PCD FILE NO: PPR 2010

GRAHAM STORAGE - LATIGO BUS CENTER, FILING 1  
 PEYTON, CO  
 FINAL LANDSCAPE PLAN

# Landscape Plan drawings\_v1 eng.pdf Markup Summary

[1] Graham Storage\_FLP\_2nd-DP L1.0 (8)

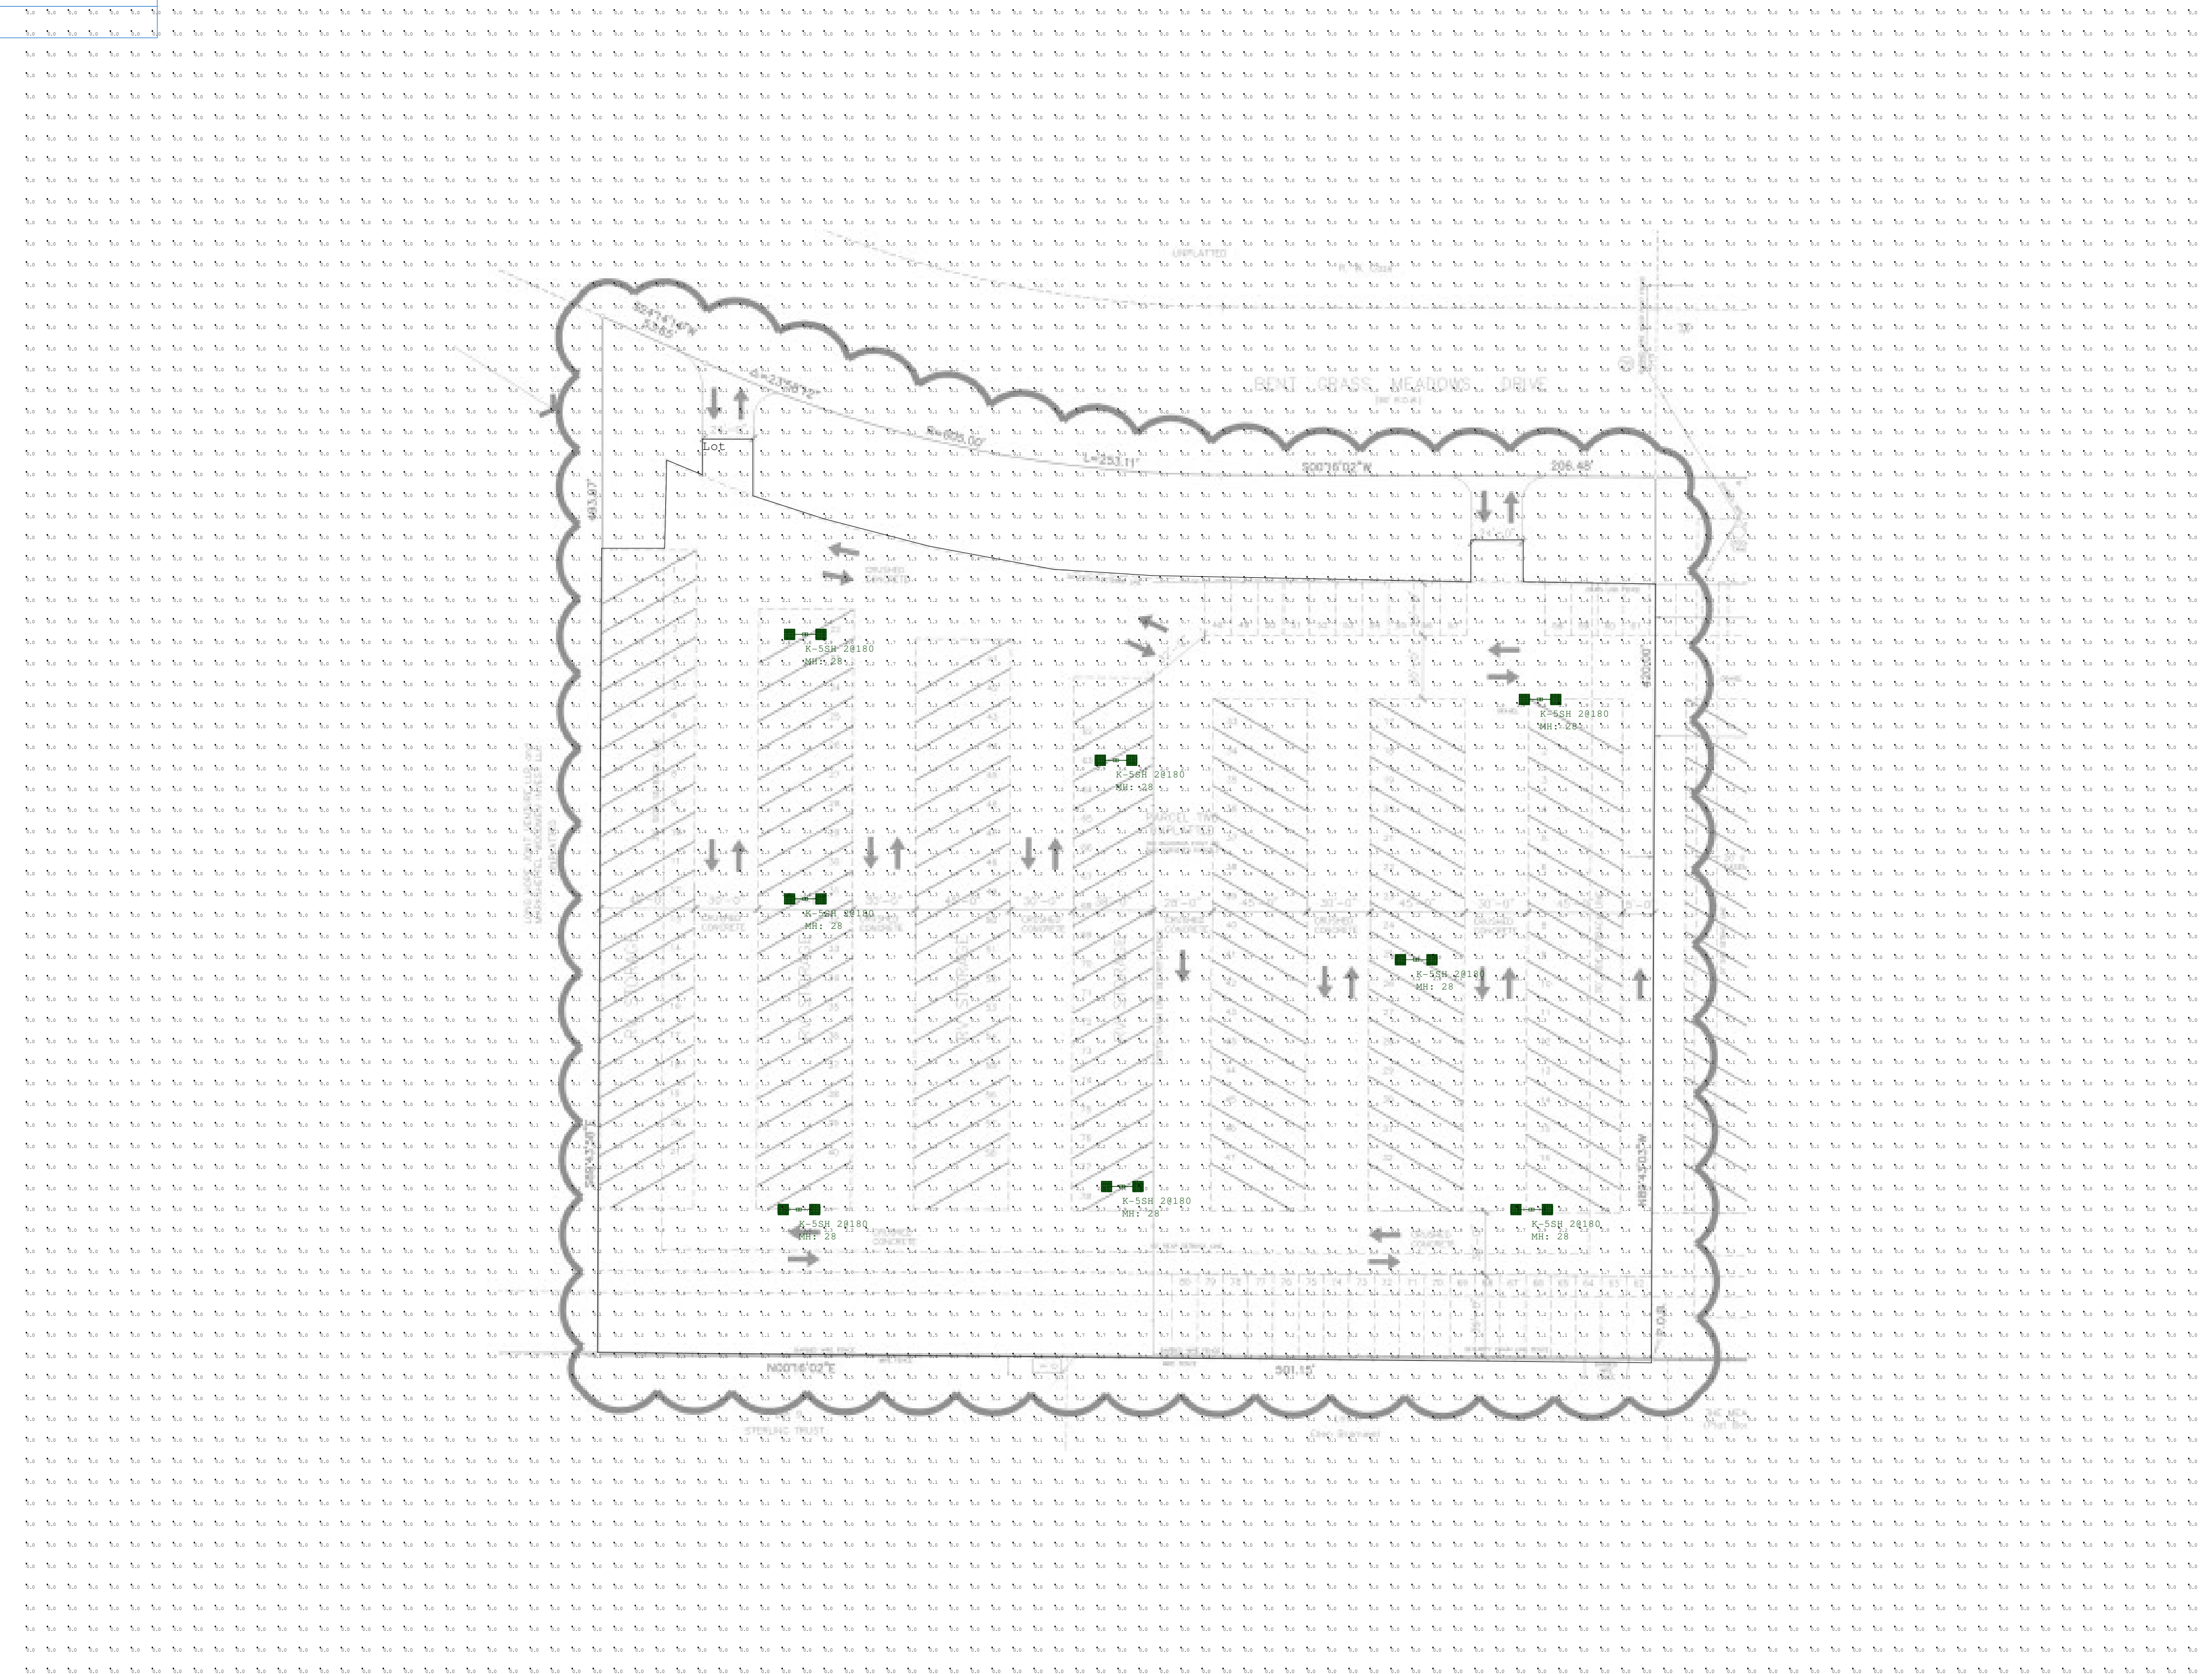
- Please depict owner or applicant: email, number, and name
- Please provide a vicinity map on the landscape plan
- Please show location and dimension of all property lines, rights-of-way, and all existing or proposed easements

- Please provide information on screening for the parking lot

- Please depict surrounding properties zoning

- Please remove/relocate the proposed trees that are within the ROW. Per ECM 2.5.8 Landscaping must be easily maintained by the use of power mowing equipment. Prior written approval from the ECM Administrator is required for plantings in the ROW.
